RE: Rader Road Short Plat SP-09-00012

TO: Community Development Services
FROM: Christina Wollman, Planner II *CW*
DATE: August 20, 2009
SUBJECT: Rader Road Short Plat SP-09-00012

Thank you for the opportunity to comment on the short plat of approximately 43 acres into 4 lots within the Ag-20 zoning district, proposed by Richard Bellis [SP-09-00012]. We have reviewed the application and have the following comments.

RADER ROAD SHORT PLAT
PART OF SECTION 17, T. 18 N., R. 19 E., W.M.
KITITAS COUNTY, WASHINGTON

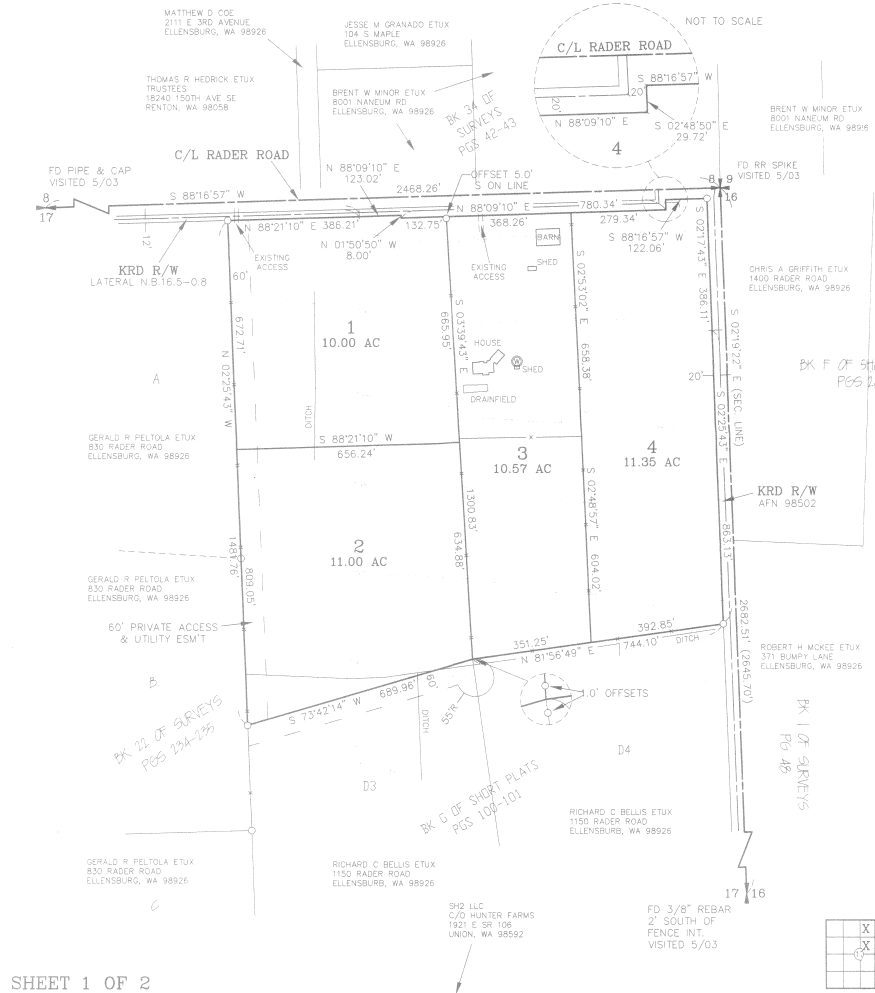
3. KRD Crossing: A KRD crossing permit or documentation from KRD that a crossing will be allowed in the future is required prior to final approval.
4. Private Road Improvements: Access from Rader Road to the cul-de-sac shall be constructed as a Low-Density Private Road. See Kittitas County Road Standards, 9/6/05 edition.

- a. Access easements shall be a minimum of 60' wide. The roadway shall have a minimum width of 20', with 1' shoulders, for a total width of 22'.
 - b. Minimum centerline radius will be 60'.

- c. The surface requirement is for a minimum gravel surface depth of 6".
 - d. Maximum grade is 12%.
 - e. Stopping site distance, reference AASHTO.
 - f. Entering site distance, reference AASHTO.

- j. All easements shall provide for AASHTO radius at the intersection of county road.
 - k. A paved apron shall be constructed at the intersection of the proposed private intersection and the county road right of way.

5. Cul-de-Sac: A cul-de-sac turn-around having an outside right-of-way or easement diameter of at least 110 feet shall be constructed at the closed end of all dead-end roads serving 3 or more lots. The driving surface shall be at least 96 feet in diameter. Cul-de-sacs must also conform to the requirements specified by the 2006 International Fire Code. Contact the Fire Marshal regarding any additional cul-de-sac requirements.

The final plat notes shall include the following two statements:

"The approval of this division of land includes no guarantee that there is a legal right to withdraw groundwater within the land division. The approval of this division of land provides no guarantee that use of water under the ground water exemption (RCW 90.44.050) for this plat or any portion thereof will not be subject to curtailment by the Department of Ecology or a court of law. "

"Metering will be required on all new residential well connections and metering results shall be recorded in a manner consistent with Kittitas County and Washington State Department of Ecology requirements."
